City of Albuquerque
Stormwater Construction Site
Inspection Report

Project Name and Location	Guardian Storage 3600 Bosque Plaza Lane NW		
Site Contact Name & Agency	Paul Hedger	ESC File No. NPDES ID No.	E12E006 E NMP 100101
Date of Inspection	3-5-19	Start/End Time	10:45/11:00
COA Inspector Name	Curtis Cherne, Stormwater Quality		
Describe Present Phase of Construction	Curbs, Landscaping, paving prep		
Type of Inspection:	<input checked="" type="radio"/> Regular • During storm event • Post-storm event (> 0.25 inch) • 311 / Complaint Response • Follow-Up		
Weather Information			
Weather at time of this inspection?		Temperature: ~60 F°	
<input checked="" type="radio"/> Clear • Cloudy • Rain • Sleet • Fog • Snowing • Windy			
Has there been a storm event since the site was Permitted? <input checked="" type="radio"/> Yes • No			
Amount: • < 1/4" • 1/4" to 3/4" • <input checked="" type="radio"/> > 3/4" • Snow _____

TITLE: GUARDIAN STORAGE EROSION & SEDIMENT CONTROL PLAN

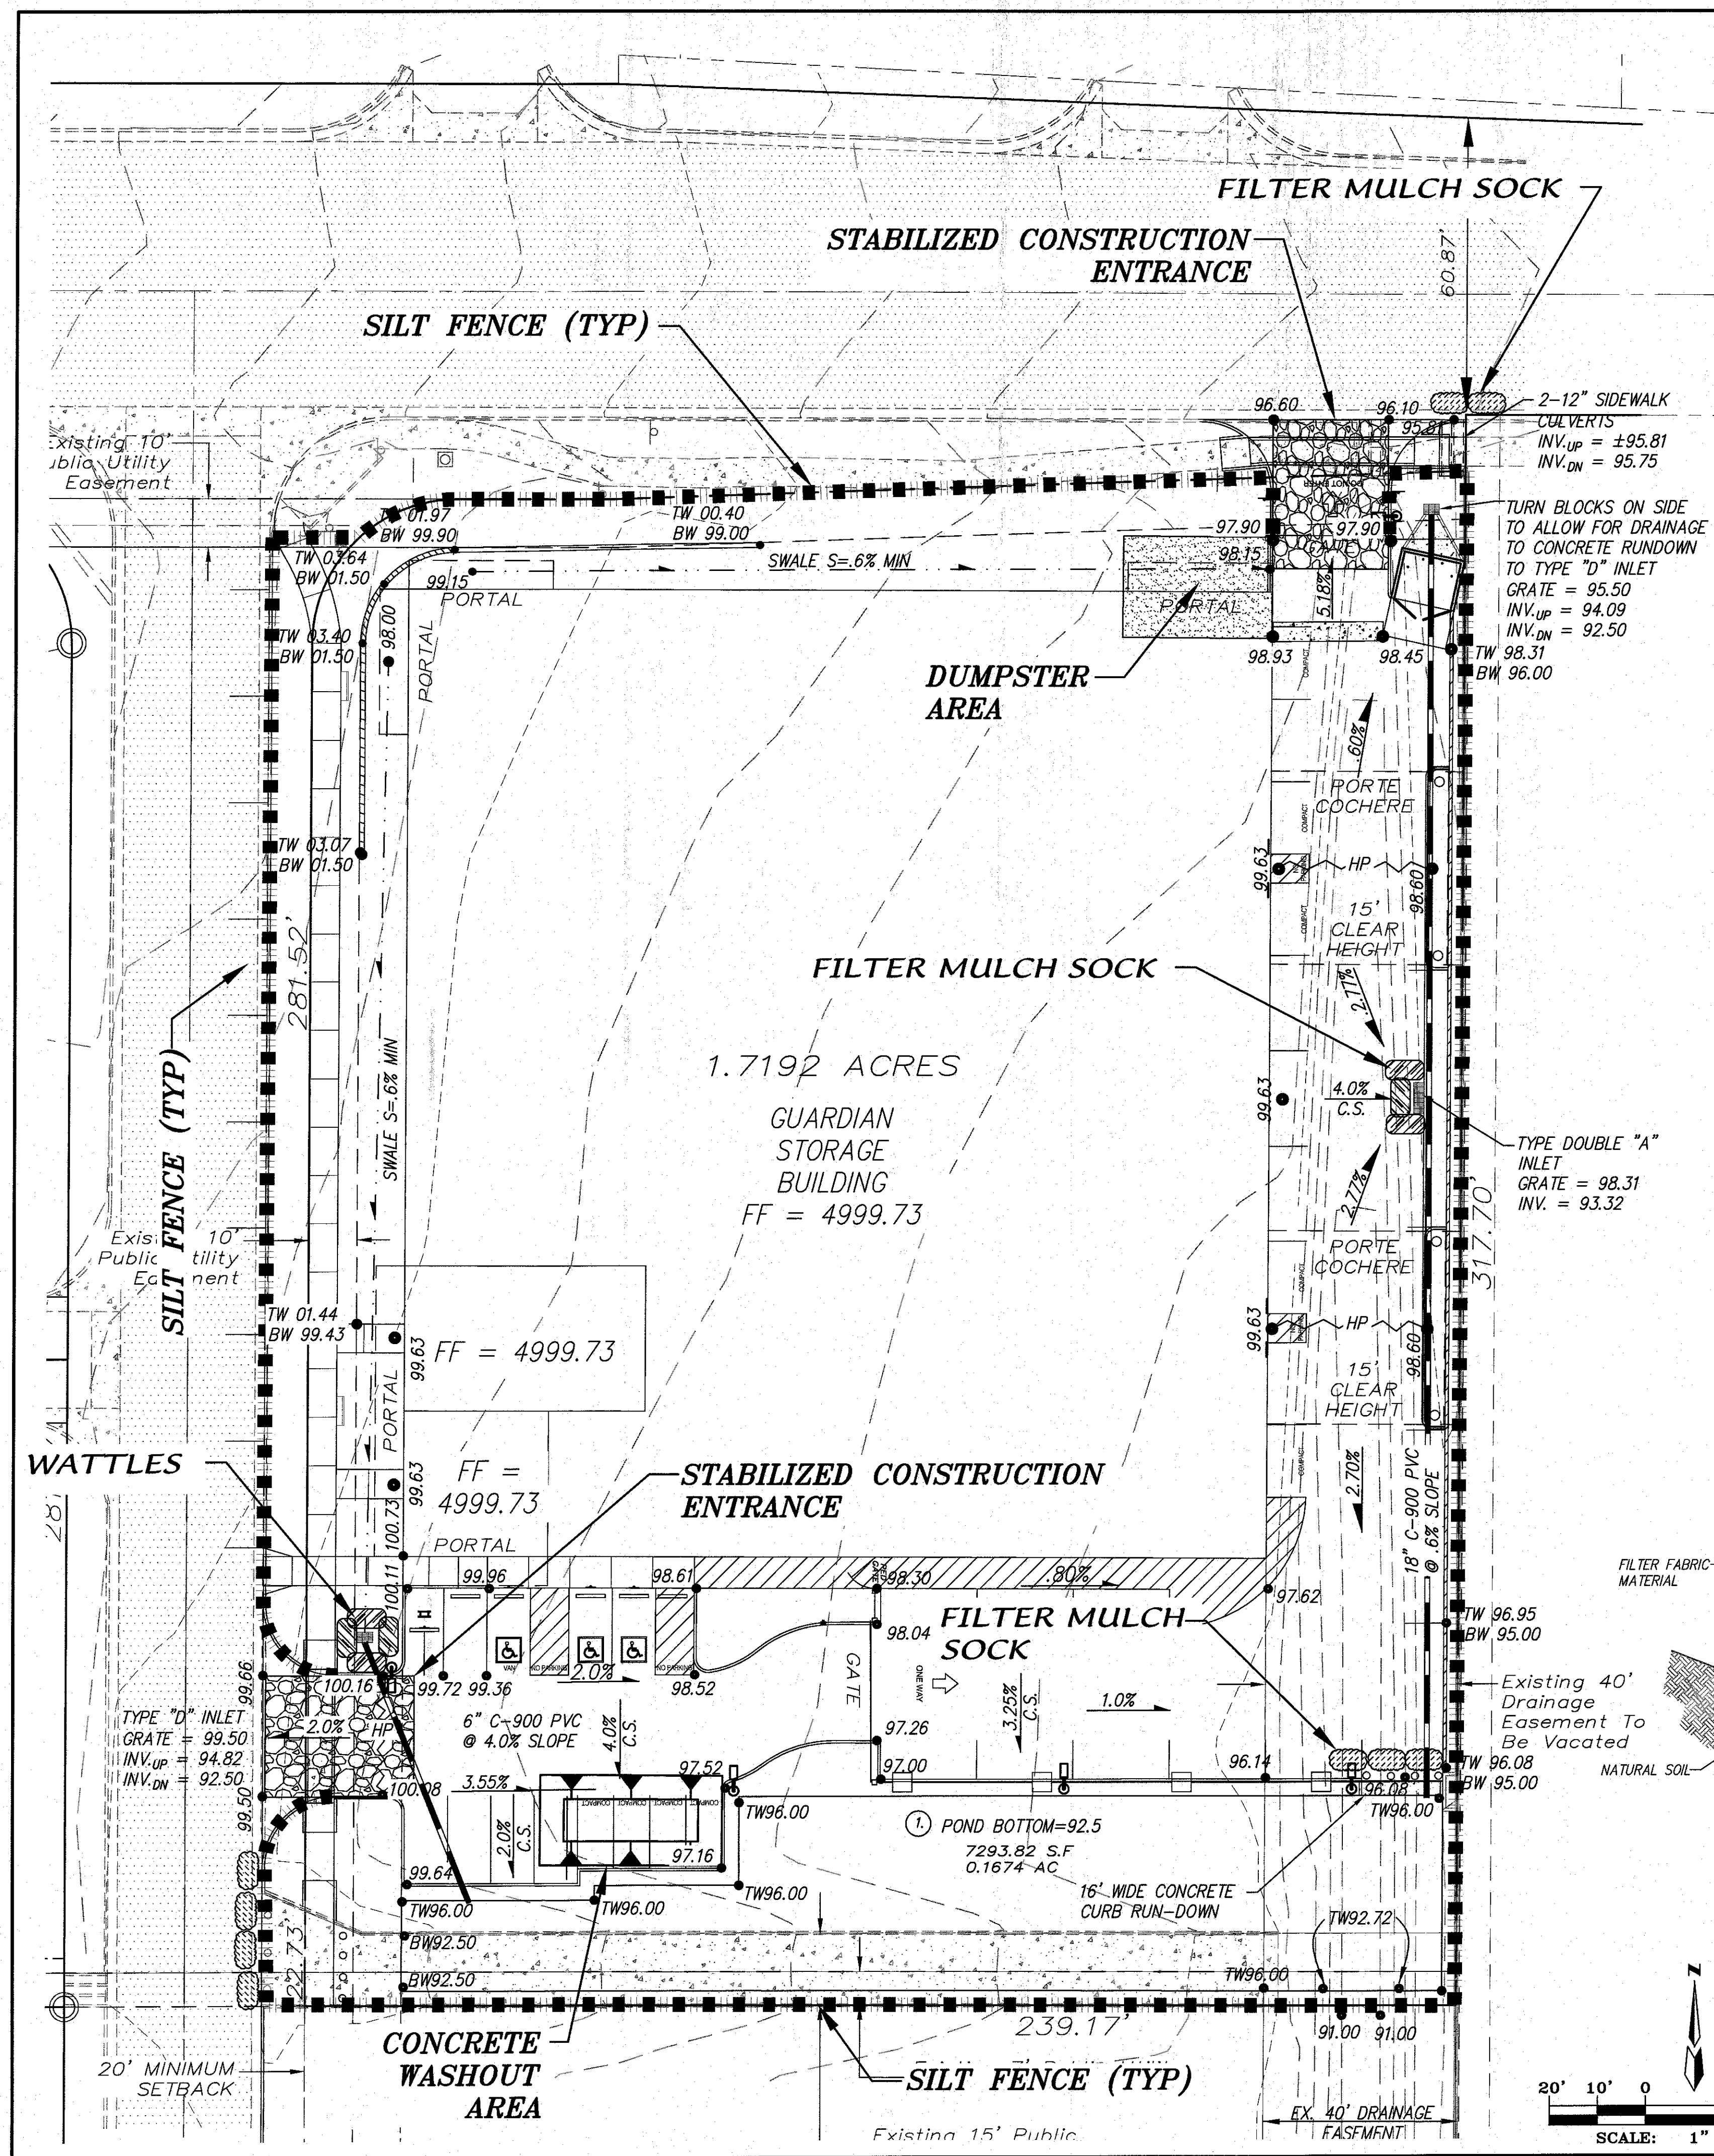
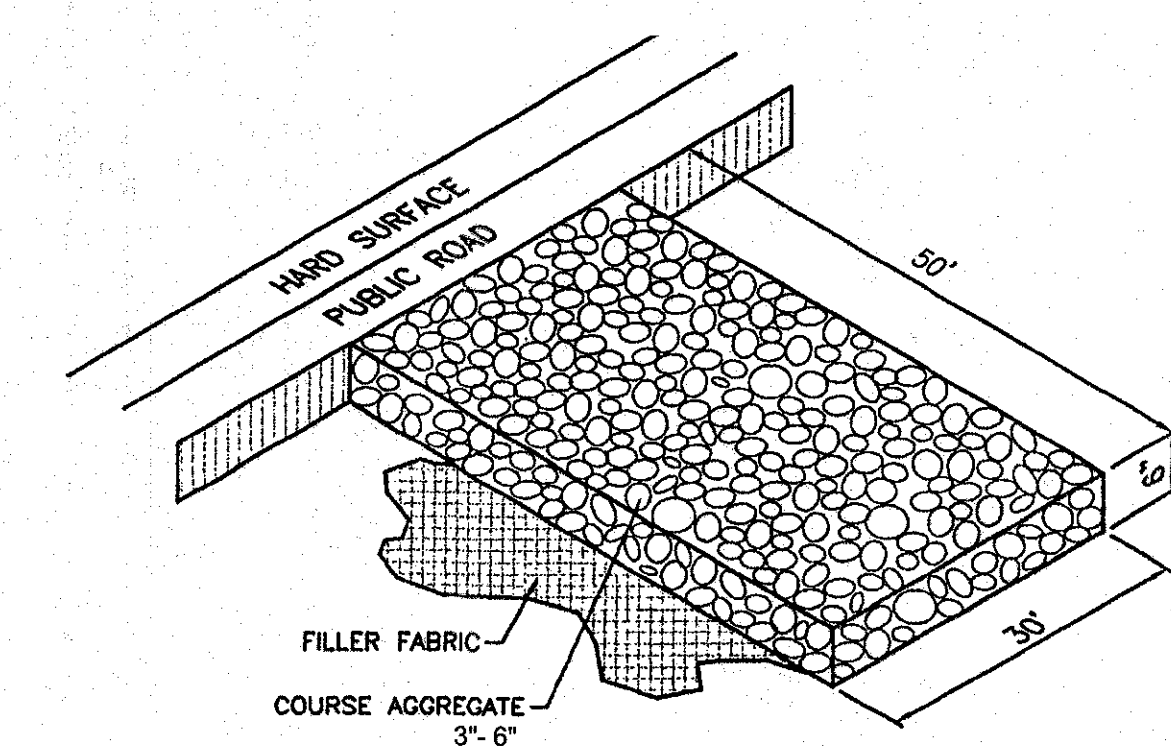
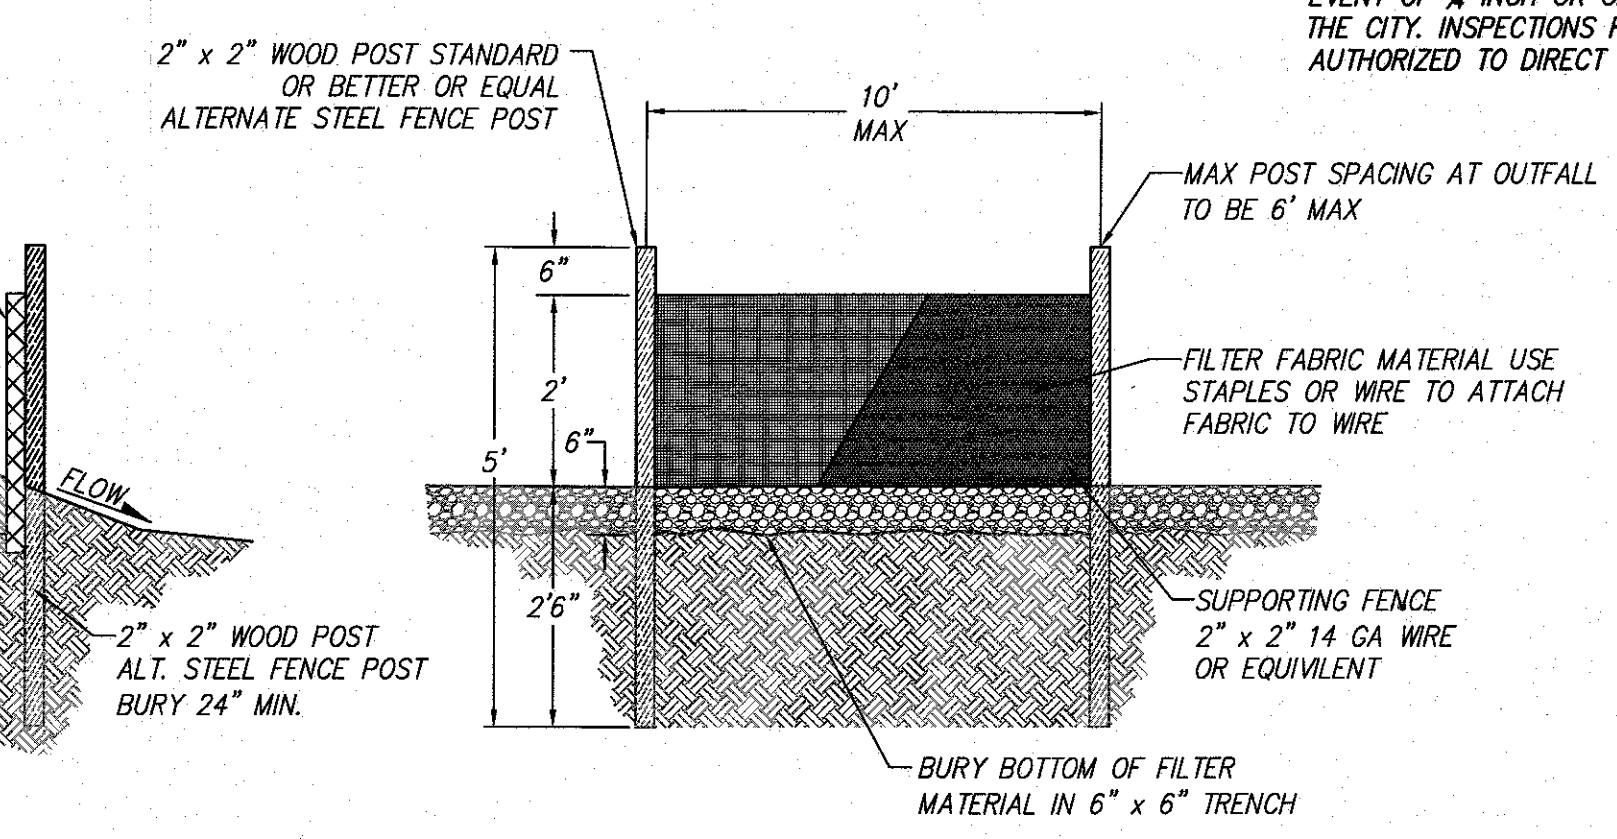
(1) Flatwork subs build dirt ramp to gain access to lot across the street

(2) Landscapers getting dirt in gutter talked to them for cleanup by end of the day

Maintenance or corrective actions are to be completed within 7 days.
